Recommendation Report

P/23/13

Development Single storey rear extension

Location 118 Pagham Road Pagham,,

sheet 2 of 2

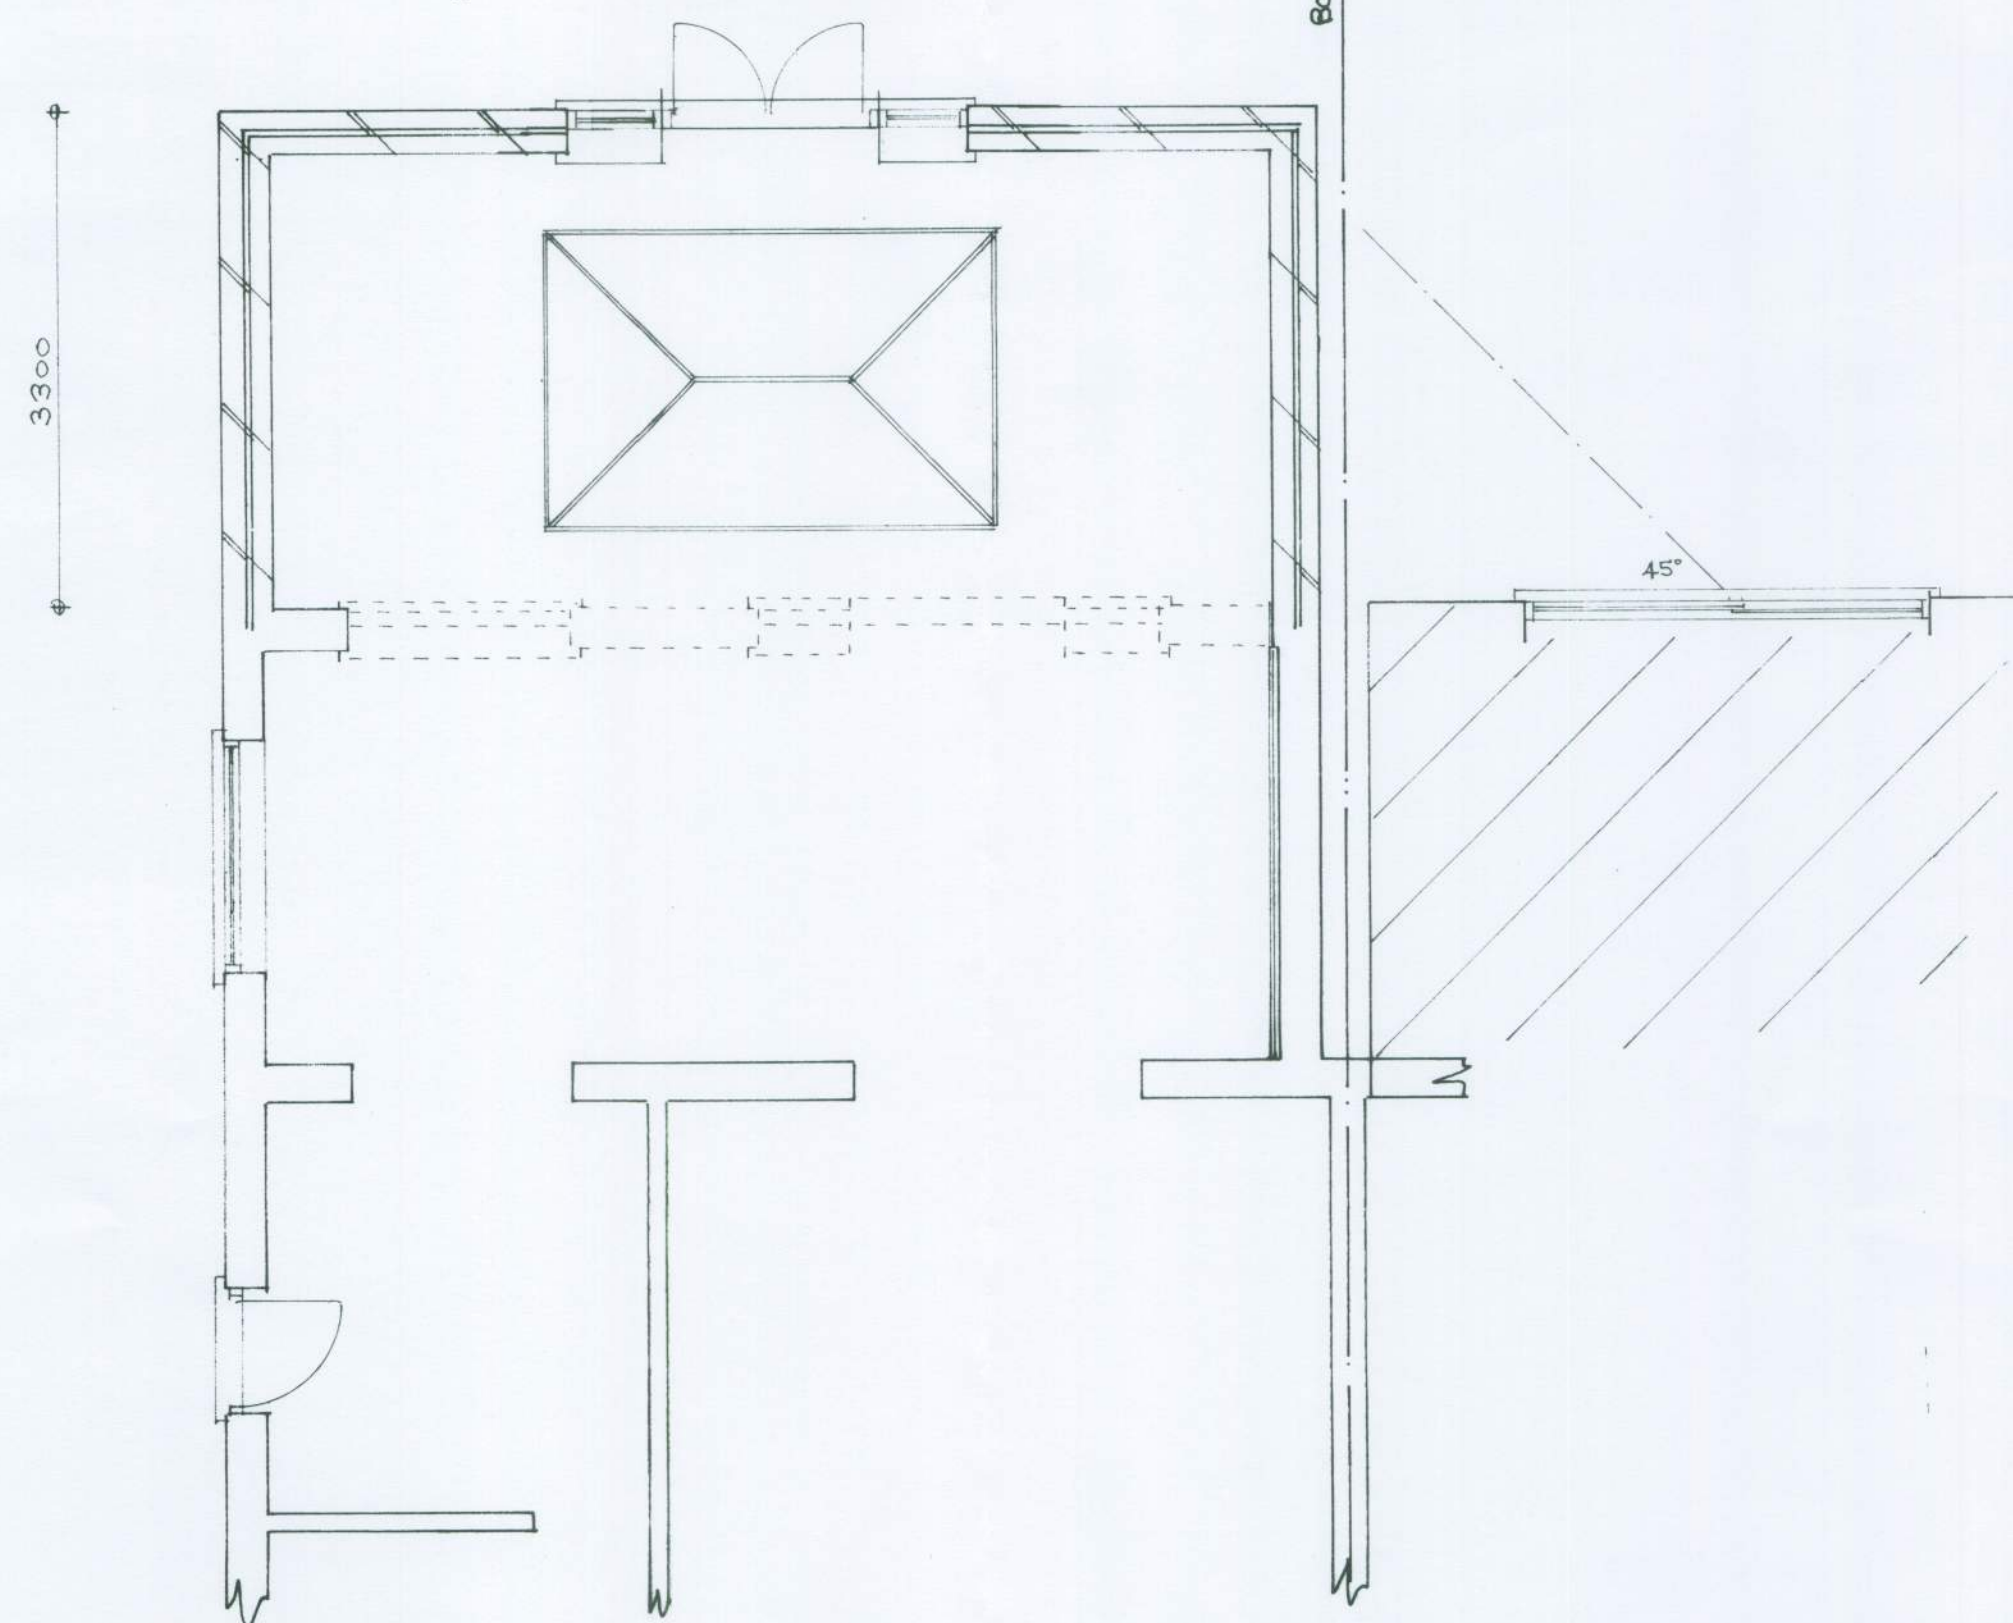
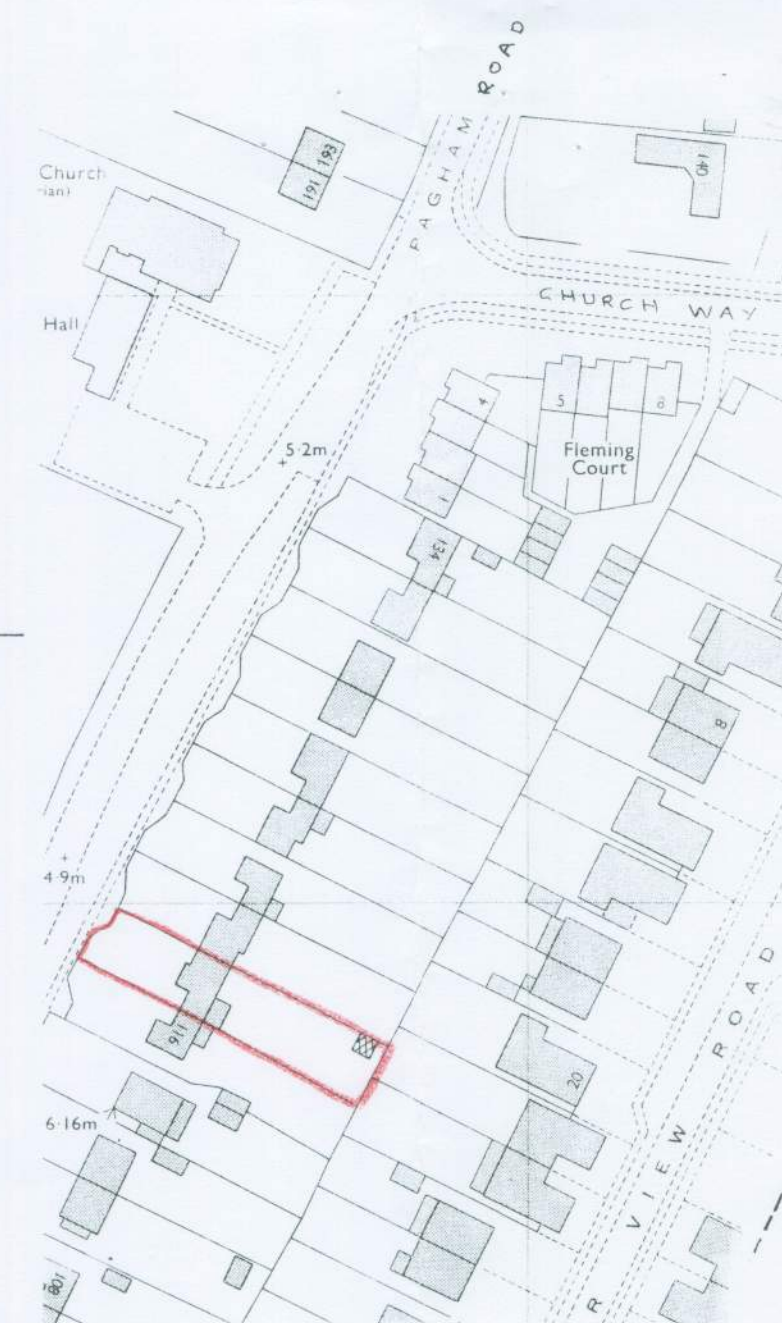
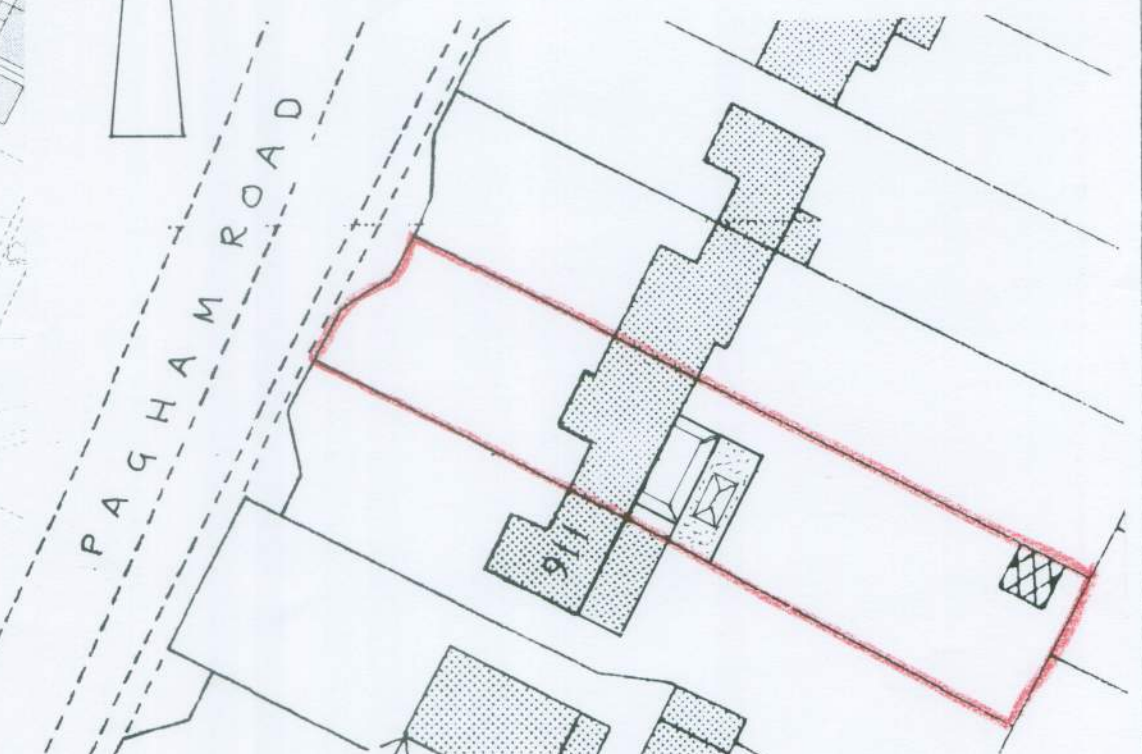
- 1/. From the drawings that I have seen, the applicant is proposing to build up to the boundary. I am responsible for that boundary, and require that I am able to keep it maintained.

- 2/. In the same vain, Mr Cooper will also need to keep his building properly maintained. I have recently approached him with regard to this, and he agreed to leaving enough room (65 Centimeters from the boundary) to allow for said maintenance without needing access to each others property.

- 4/. There is also the problem that he is intending to build within 1 Meter of the Soakaway for my flat roof, which on my plans states "Soakaway 15 ft from any building" See P/117/82BR 20-09-1982.
It would also mean that he would also be building over the Soakaway of his own ground floor extension added later to his property.

- 6/. There is also the question of rain water run off. His first floor extension added a huge area to the roof.
This has been connected into the down pipe for the original 1956 Soakaway, which is now under the floor of his House.
There seems to be no mention of how the run off from this latest extension roof will be got rid of, as I believe we are not allowed to dispose of it down the local sewers.

Existing

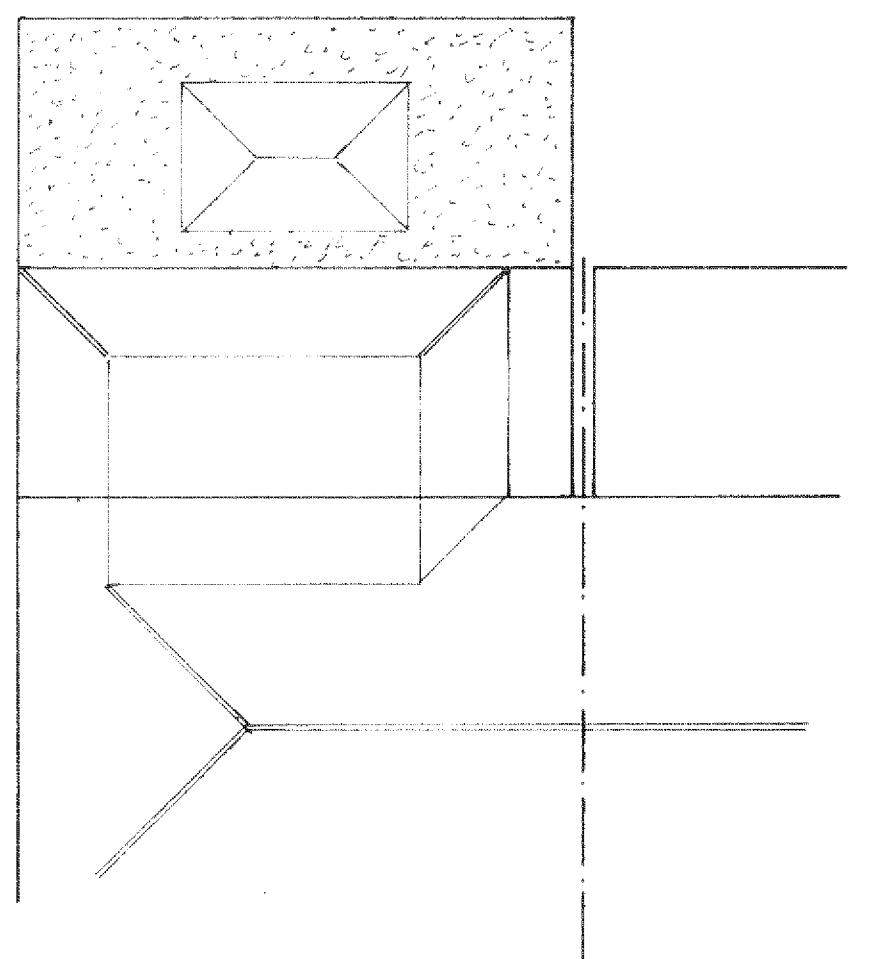
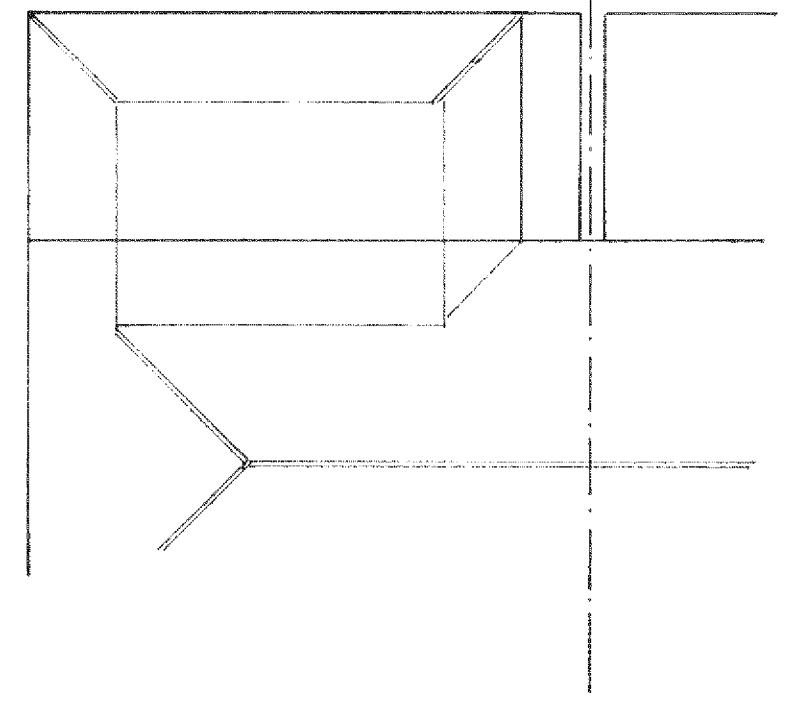
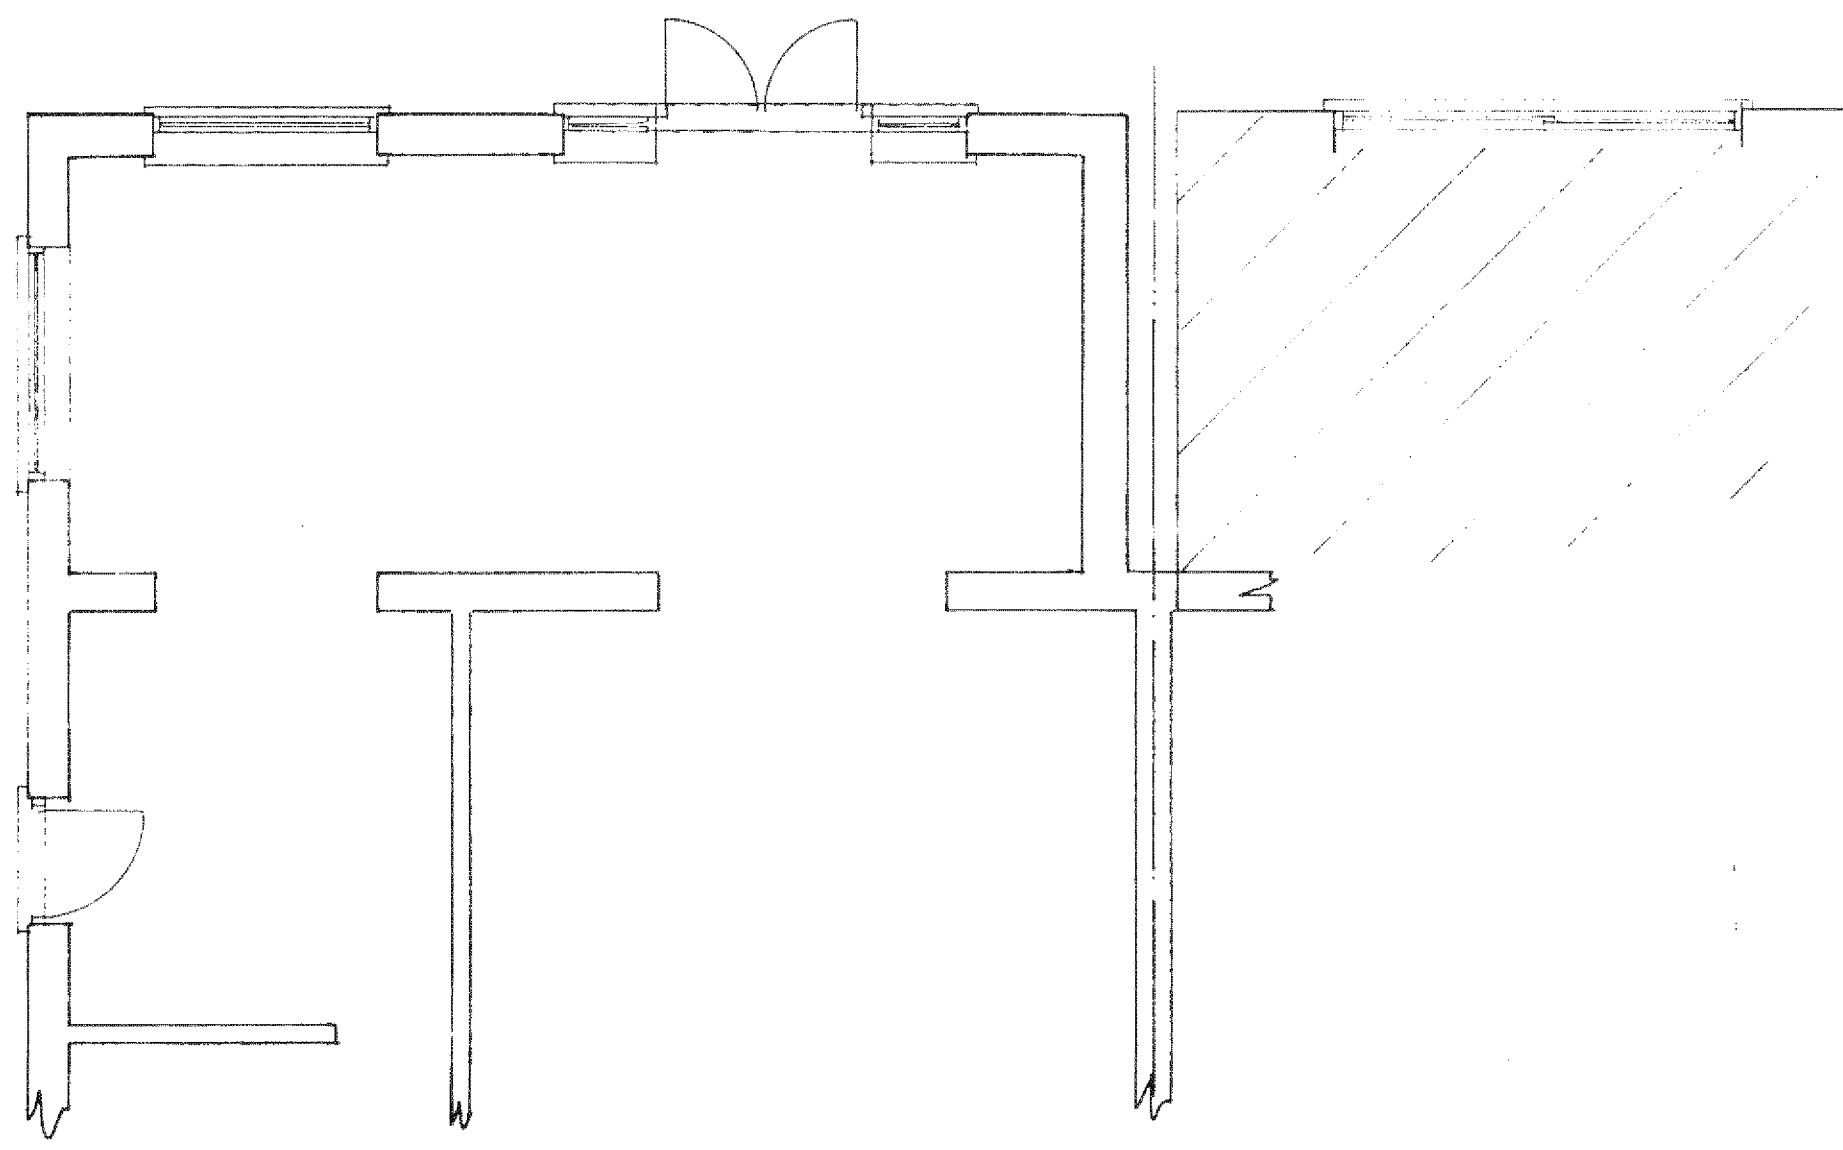
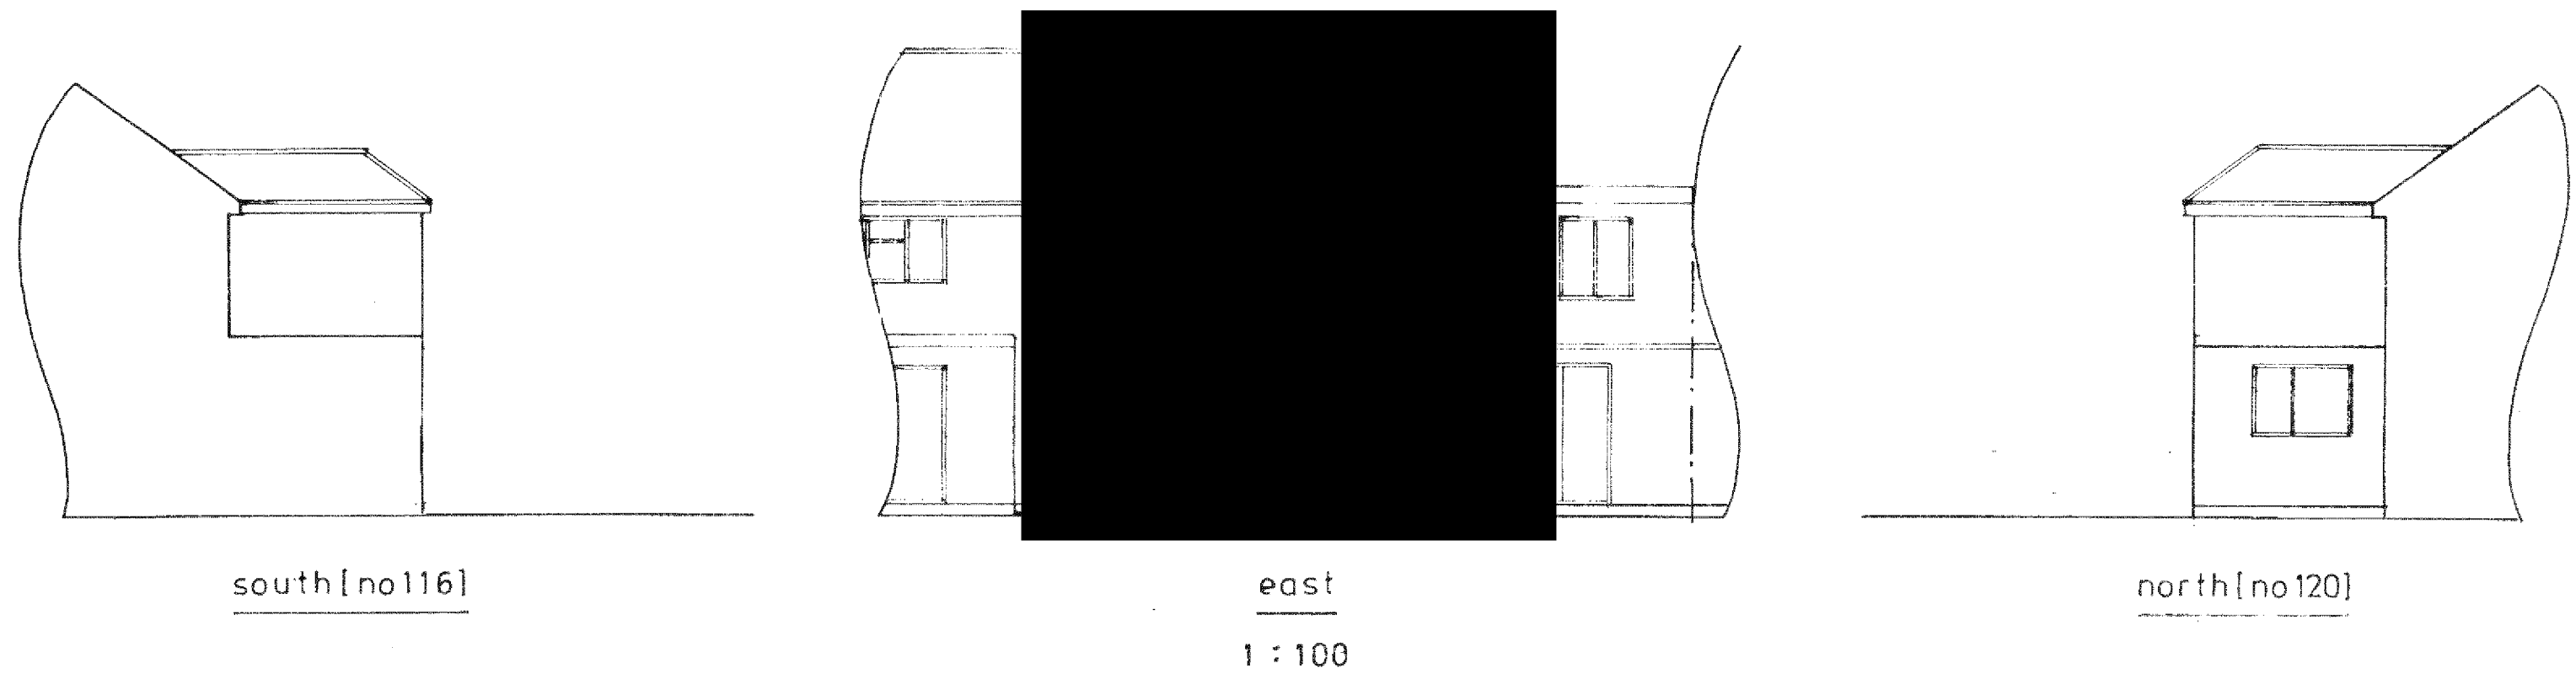
The existing East elevation does not accord with the existing East floor plan. Please amend accordingly. ✓ 22-3-13
